Our Ref: F/15/15/HH
Your Ref:

Town & Country Planning Act 1990 (as amended)
Town & country Planning (Development Management Procedure) (England) Order 2015
Application for Planning Permission for Works or Extension to a Dwelling

Development Single storey rear extension & new side porch
Location 7 Wicks Farm Cottages Ford Lane Ford

BLOCK PLAN
1.500

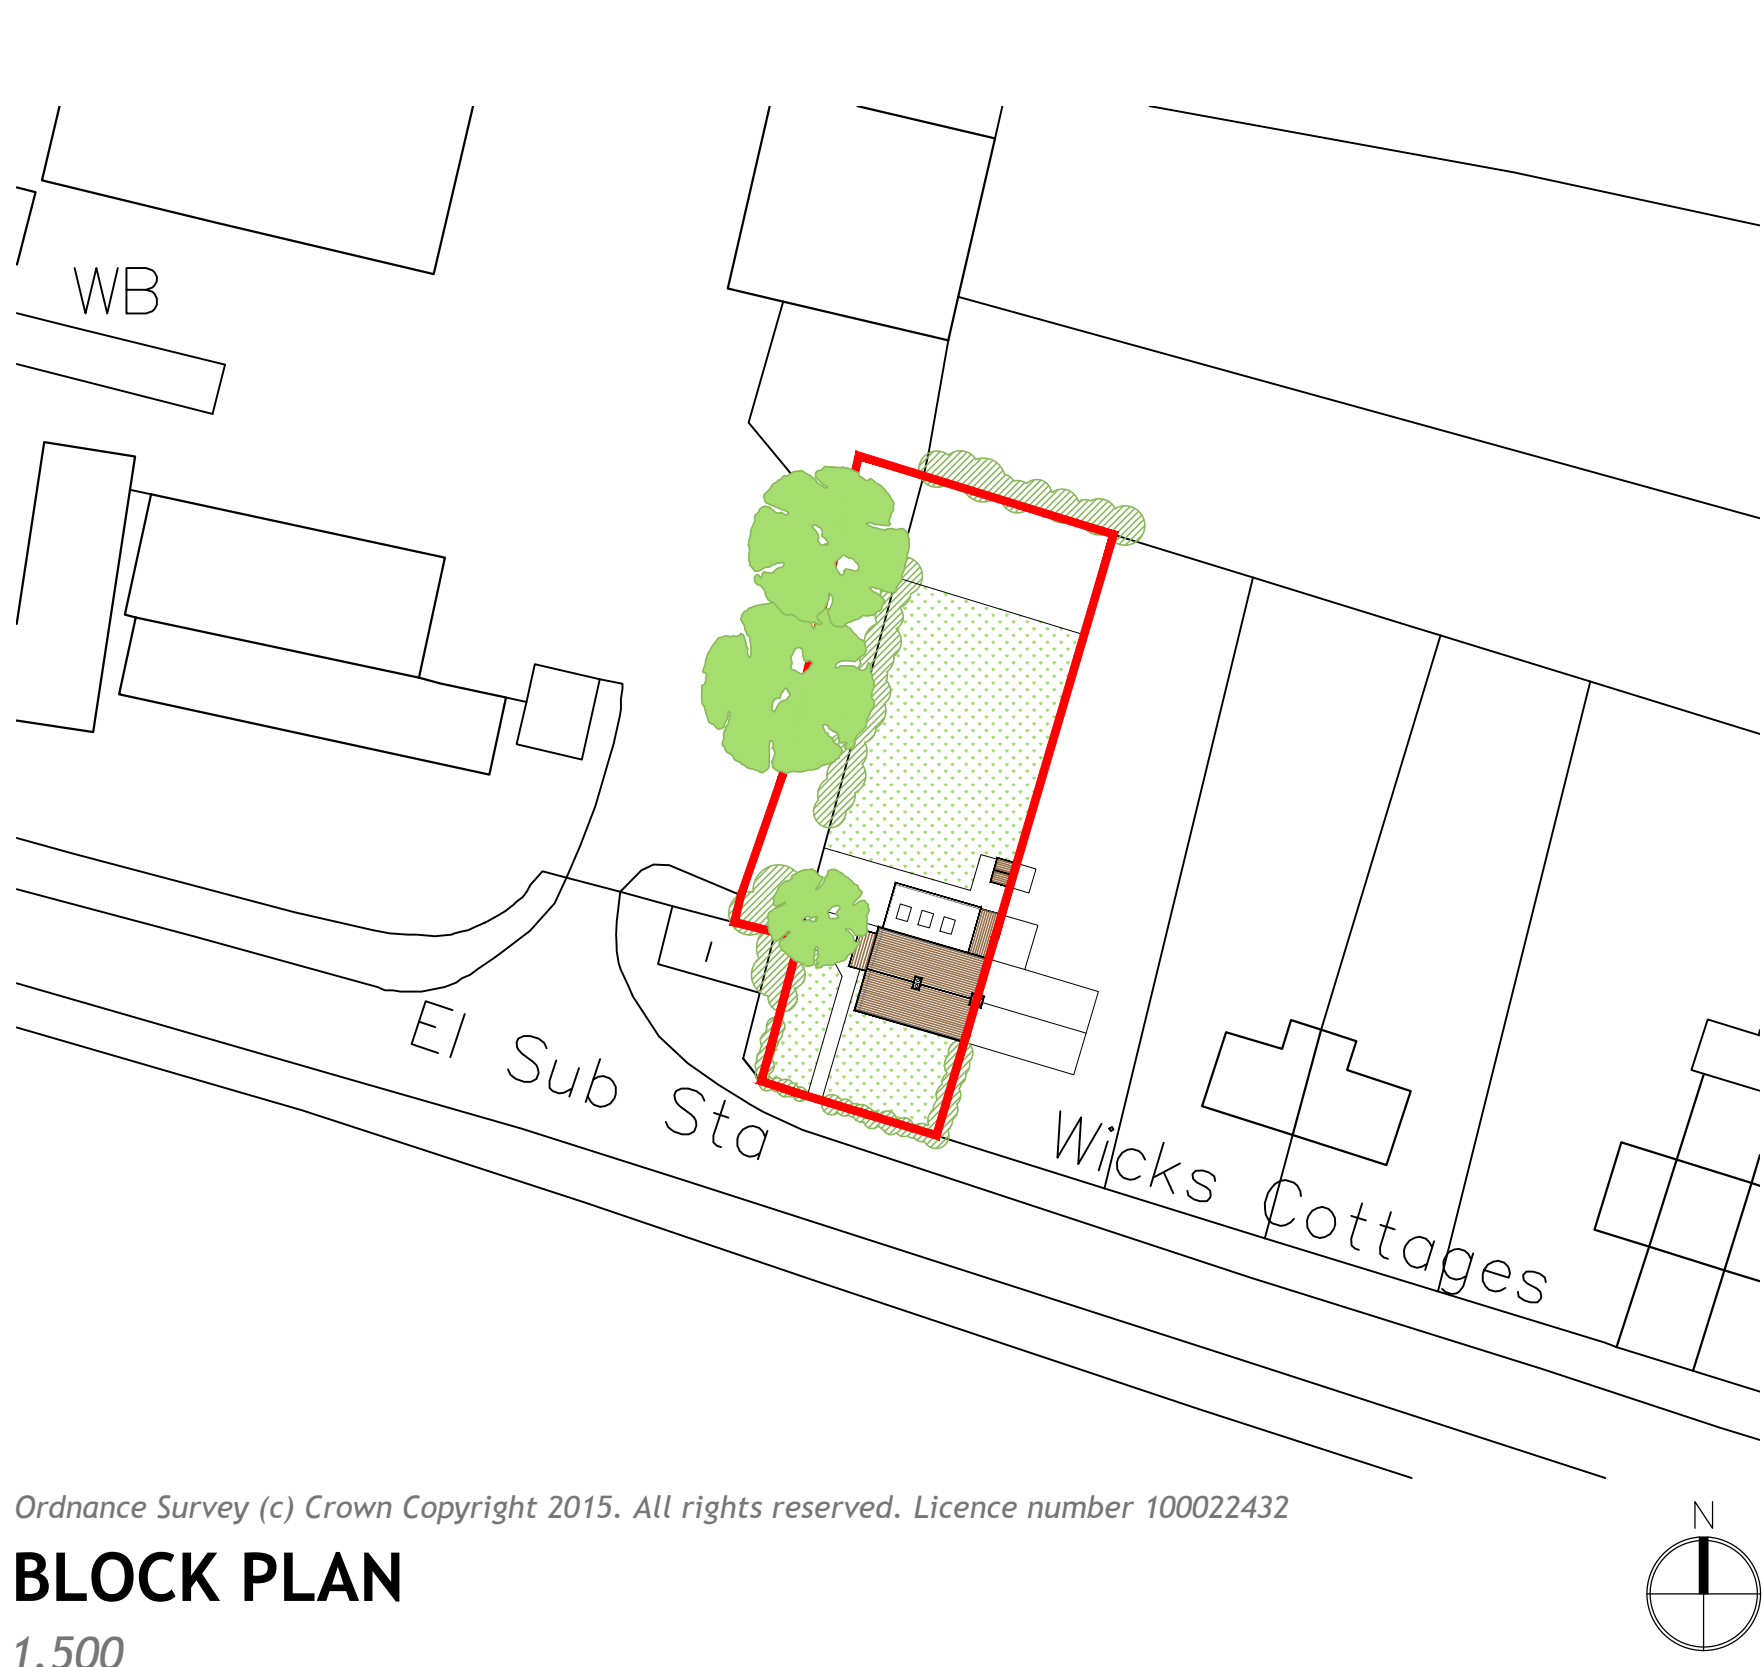
Block Plan

Please submit 1 electronic or 3 paper copies of an amended block/site plan at a scale of 1:500 or 1:200 to show measurements to each boundary
